Date: 12 April 2022  
Our ref: 385680  
Your ref: 2022/0115

**Planning consultation:** 215 dwellings with associated car parking/garages, landscaping, public open space including both equipped and non-equipped areas of play, SUDS and drainage, with details of a new vehicular access onto Shaw Lane.

**Location:** Land north of Shaw Lane, Carlton, Barnsley, S71 3HH.

**SUMMARY OF NATURAL ENGLAND'S ADVICE**

**Figure 6-3** Critical Load Function for Ecological receptor E1

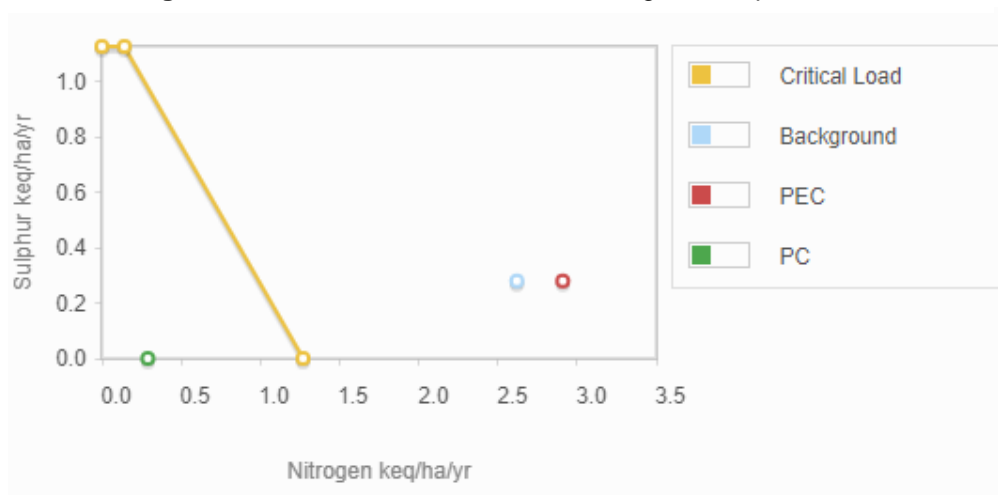
The assessments of nitrogen deposition and acid deposition appear conflated. It is not clear whether the conclusions provided under Tables 6-15 and 6-16 relate to nitrogen deposition or acid deposition. Natural England expect that the potential environmental effects of nitrogen deposition and acid deposition will be assessed separately. The results of any assessment should be clearly explained and justification provided as to why the proposed development will not result in a significant impact to the features of the designated site.

In assessing the potential environmental effects, we recommend that the source of the data be made absolutely clear. For example, it is not clear how the Critical Load for nitrogen deposition at Dearne Valley Wetlands (SSSI) (E1), presented in Table 6-14, has been derived.
